Conservation Area Advisory Committee

Meeting Date : 7 September 2015

Ref	Description	Address	Design award
LU/237/15/PL	Removal of old front porch & installation of new front porch, replacement of glazing to 2 No. ground floor front bay windows, 5 No. first floor front Georgian sash windows & 2 No. second floor front dormer windows & installation of former railings to forecourt perimeter. This application affects the character & appearance of the Littlehampton River Road Conservation Area. (Resubmission following LU/306/14/PL.)	The White Hart Public House 32 Surrey Street Littlehampton BN17 5BH

PROPOSED PLAN, FRONT AND SIDE ELEVATION
at: THE WHITE HART PUBLIC HOUSE,
32 SURREY STREET, LITTLEHAMPTON, WEST SUSSEX BN17 5BH

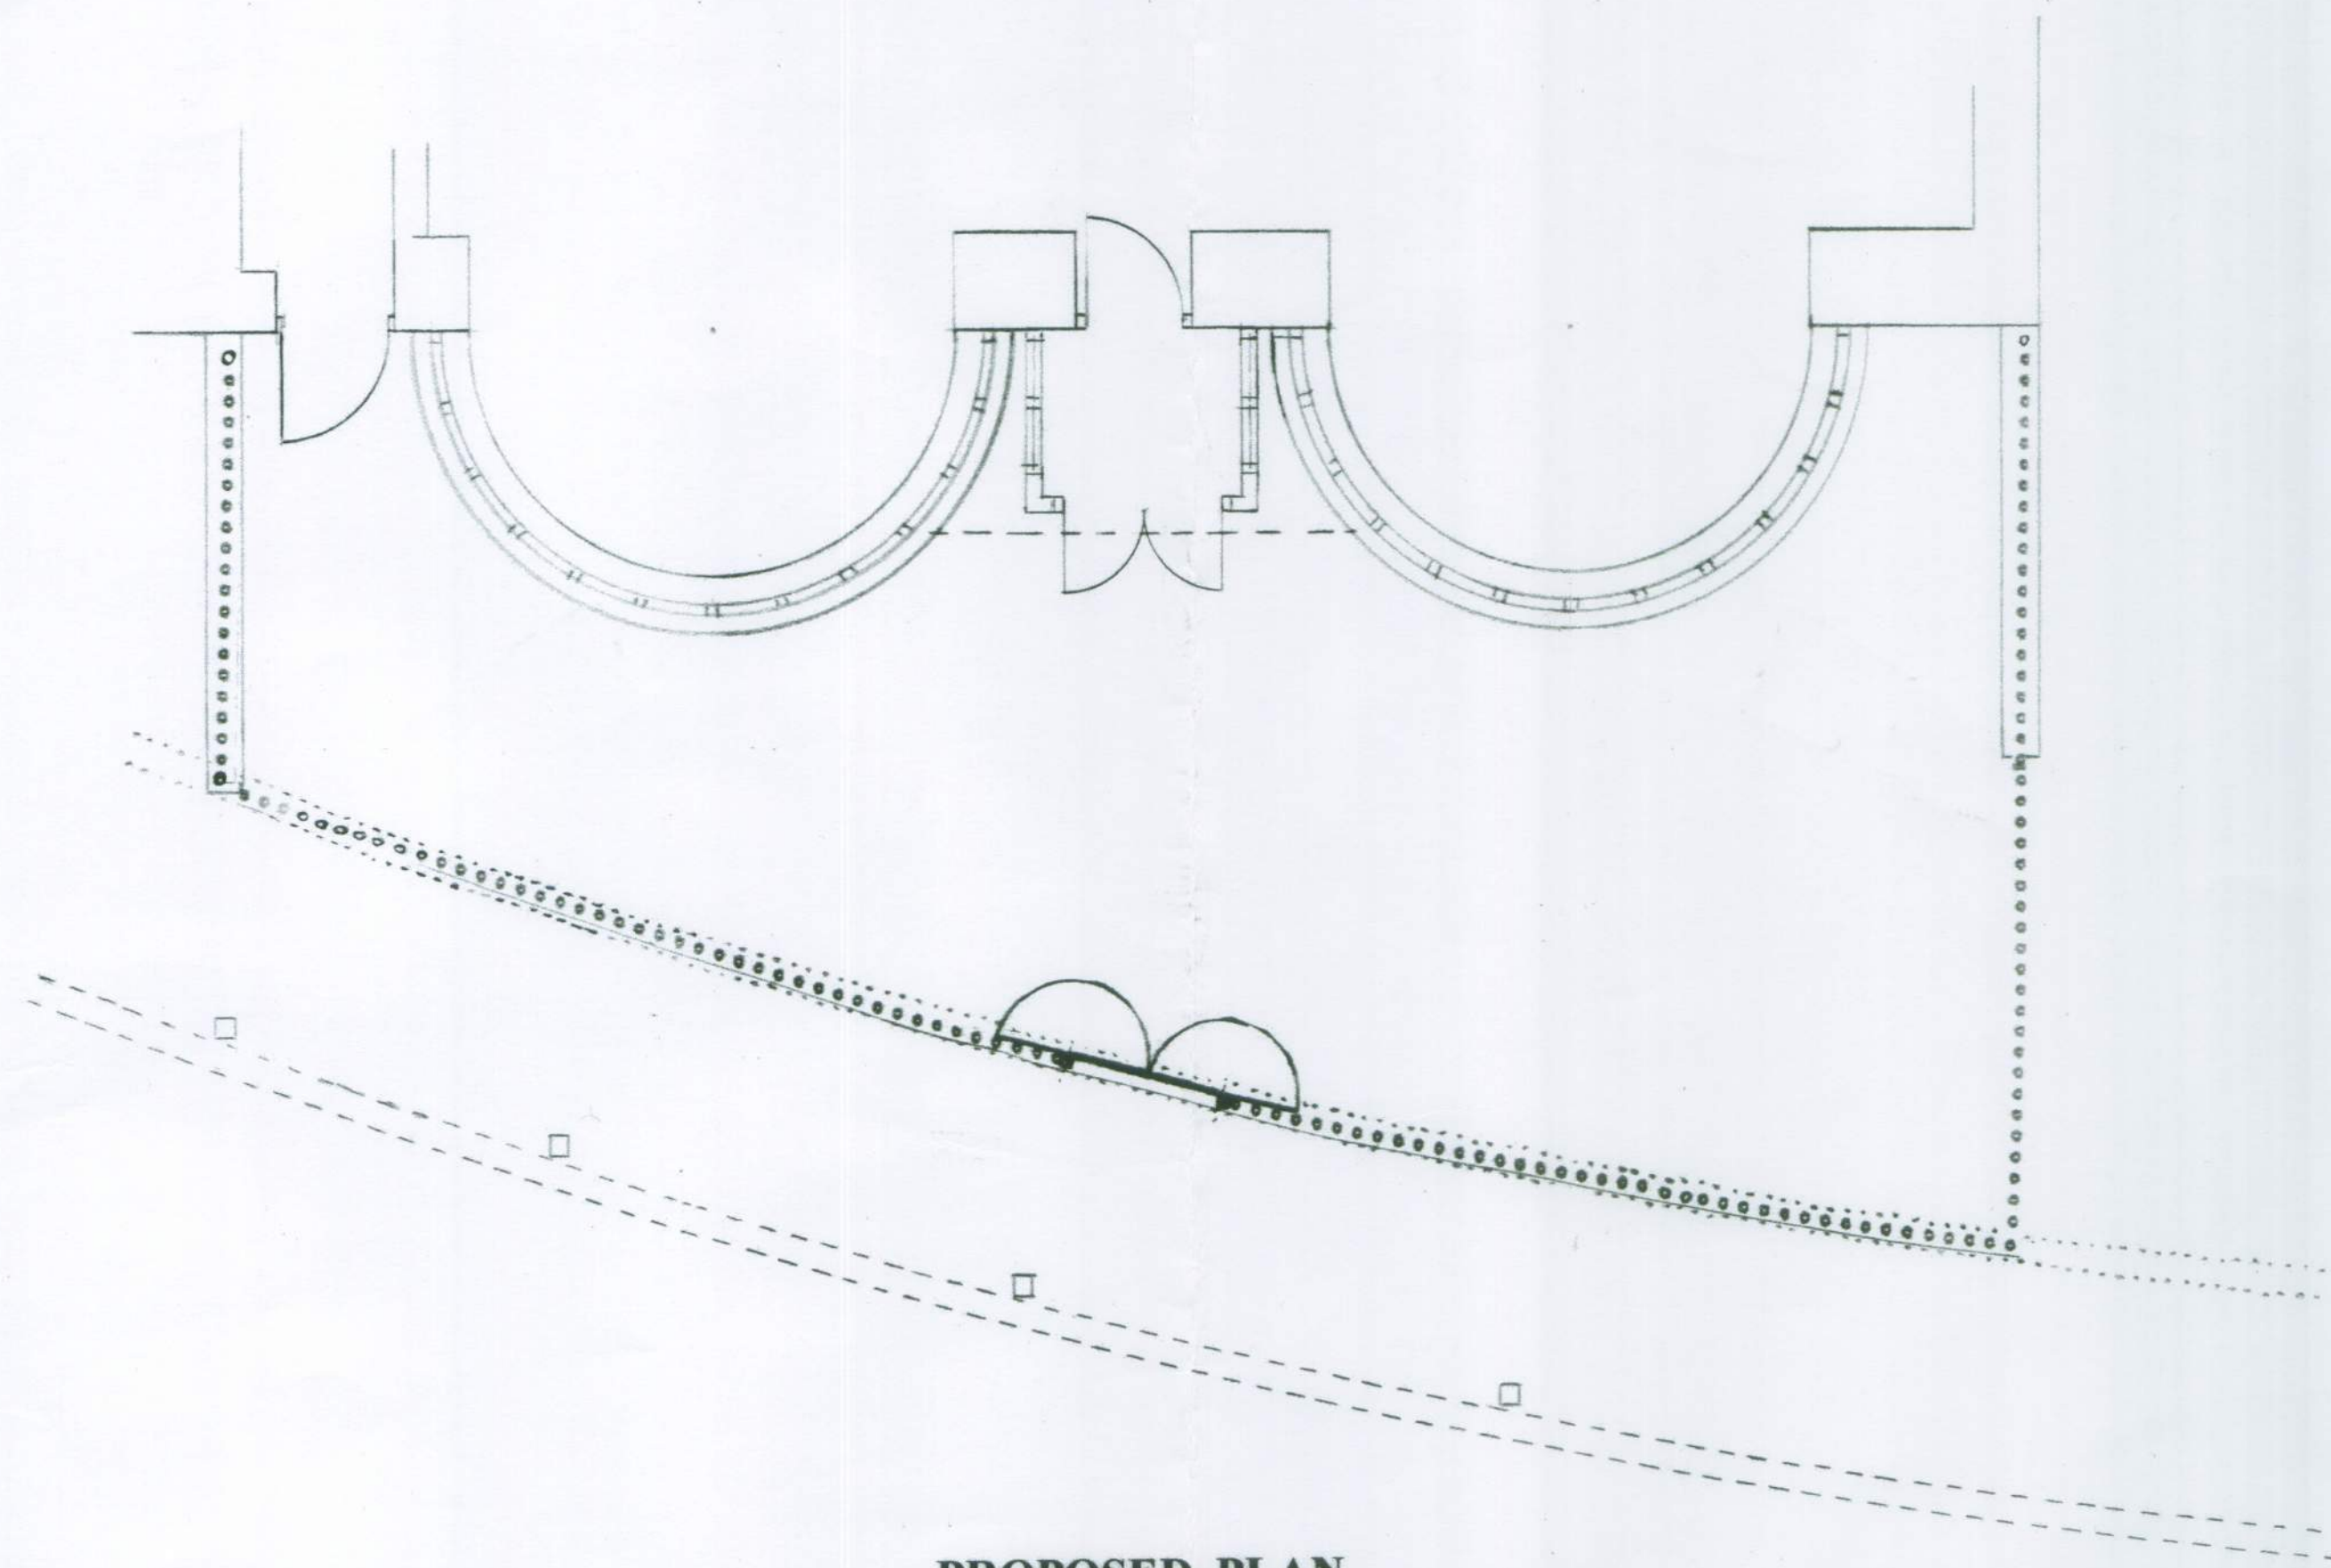
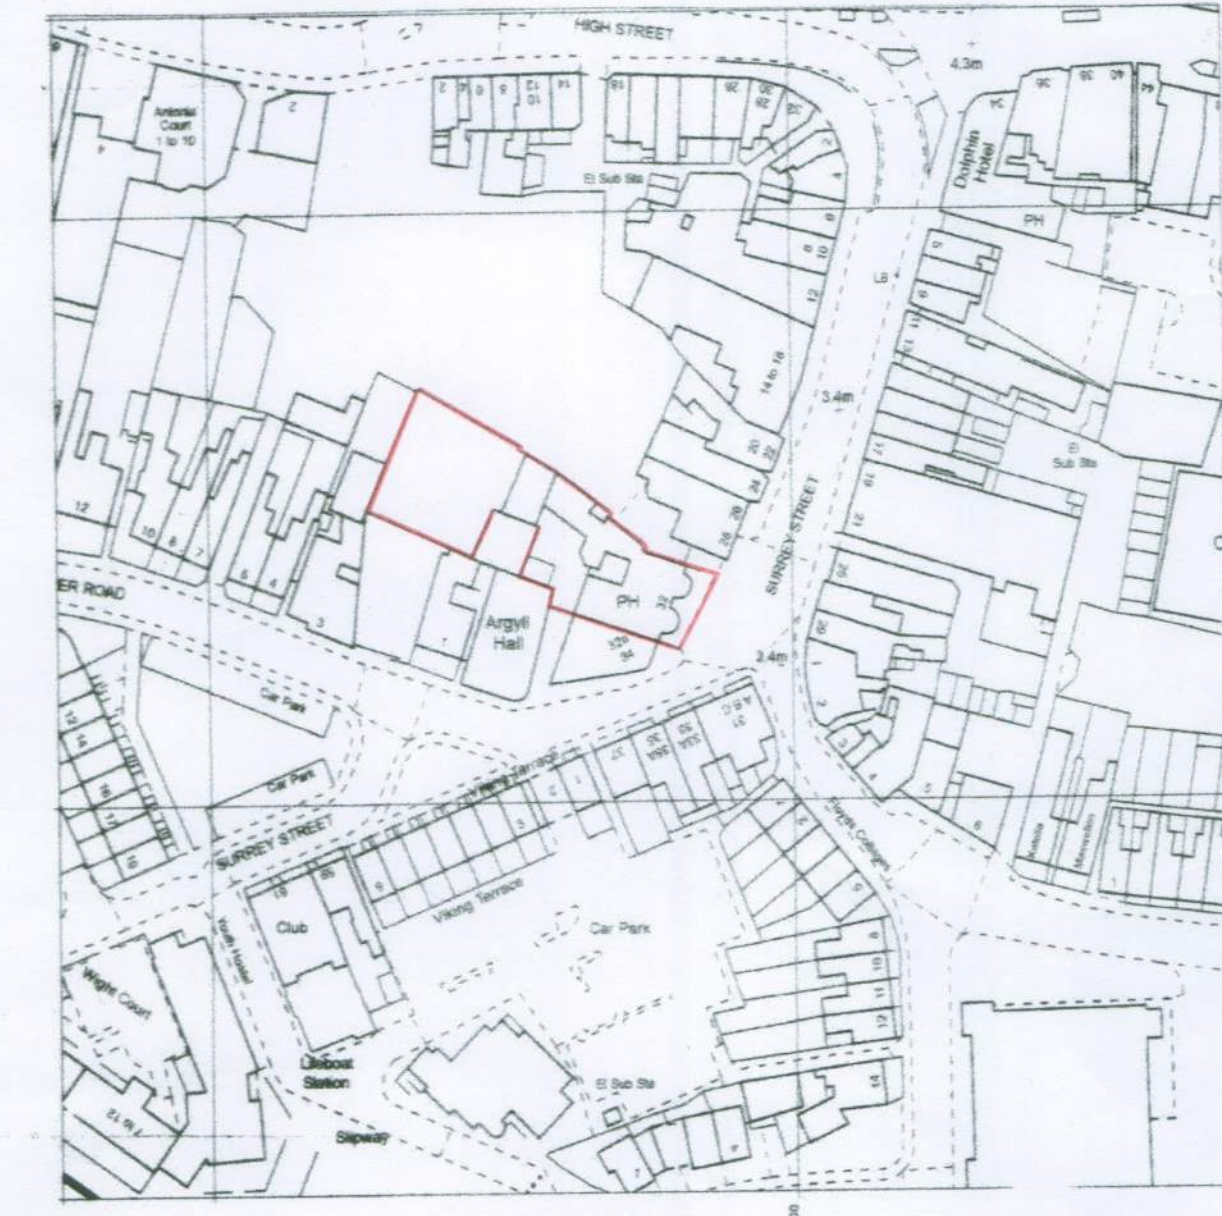
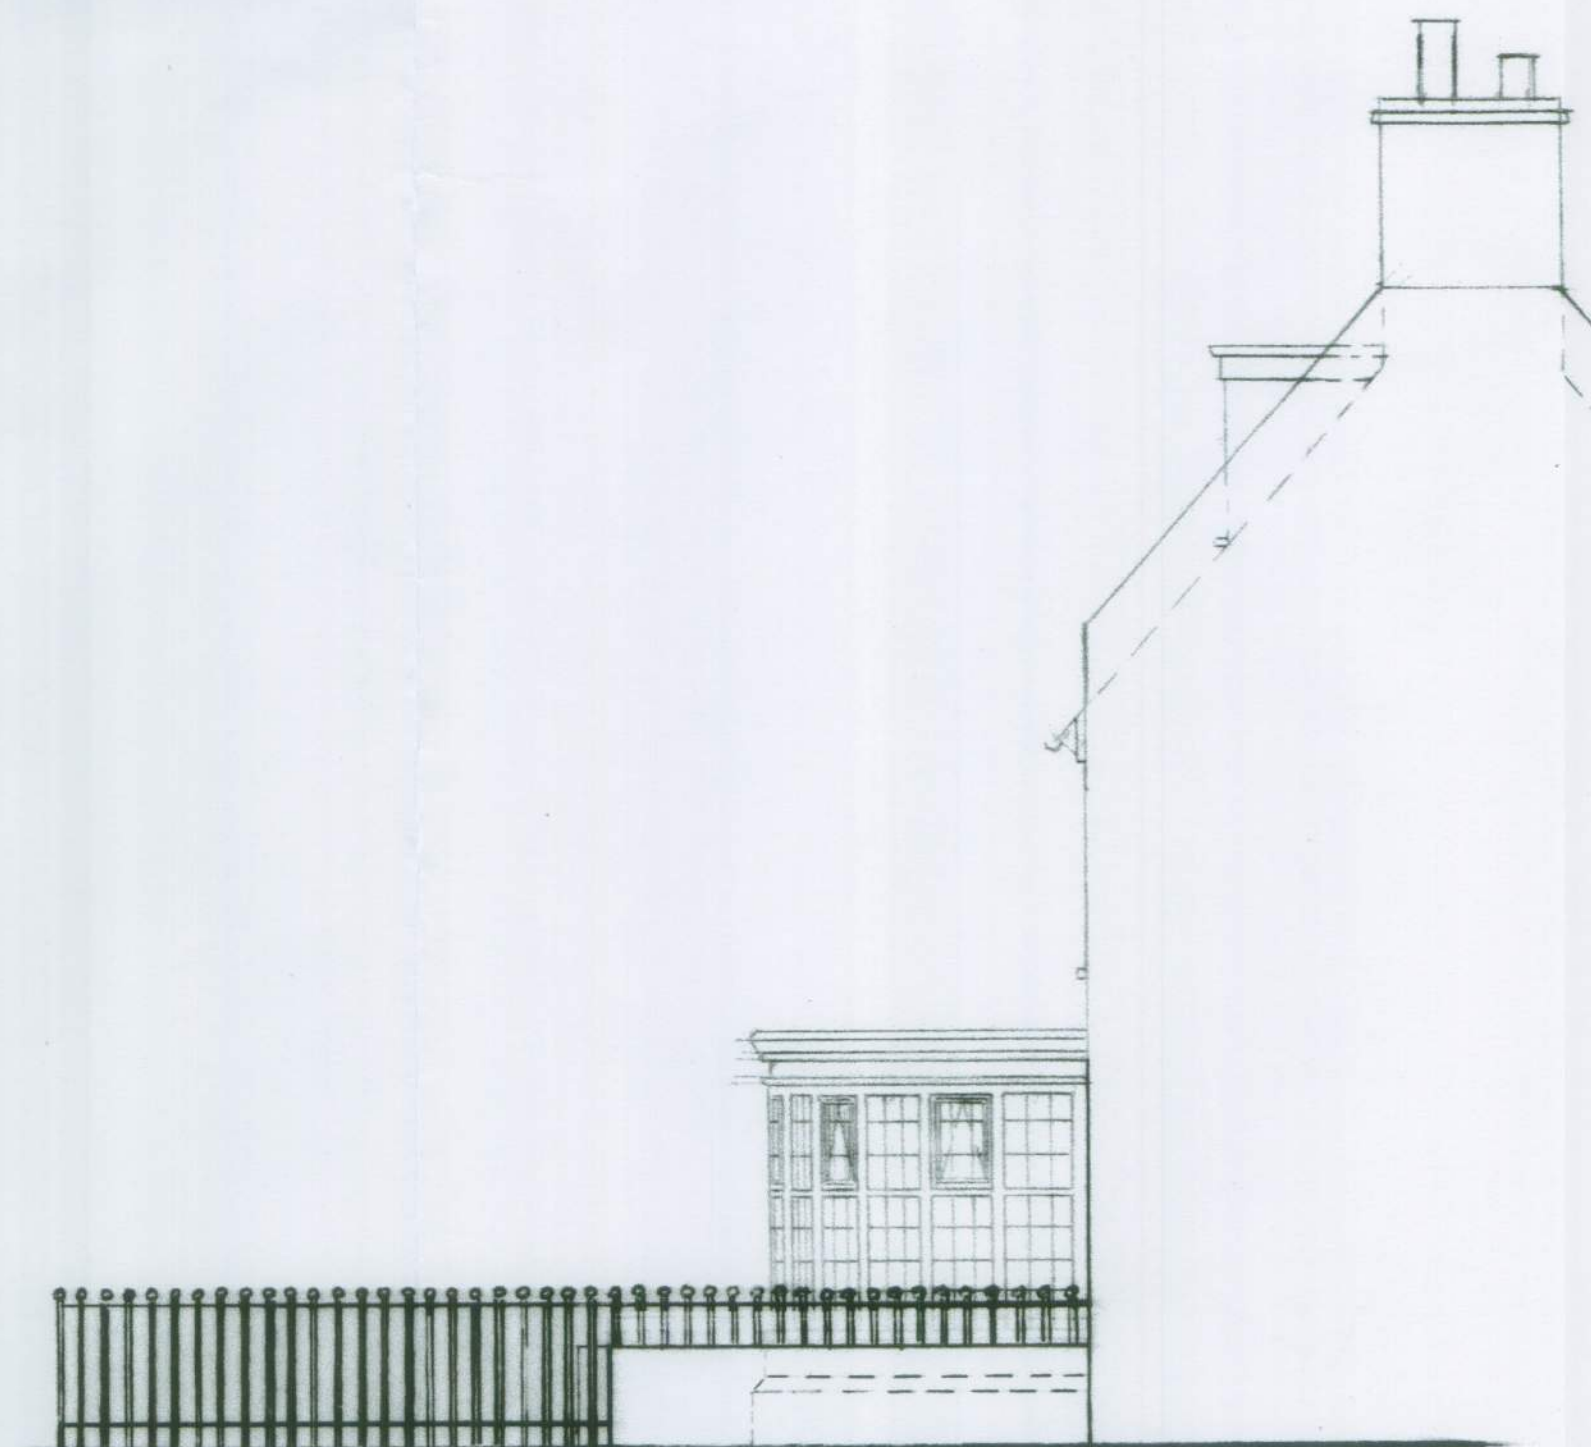
Comments: re Windows - These should be refurbished by specialists & not replaced, retaining as much of the original timber & glass as possible.

Suggested Conditions: the original timber & glass as possible.
Comments re Porch - ~~Objections~~ Would like more detailed plans of porch to enable us to comment - suggest an alternative approach would be to have an internal lobby & remove the existing porch with perhaps a small canopy.

Comments re Railings - Objection - overpaving & out of keeping
Suggest sides only
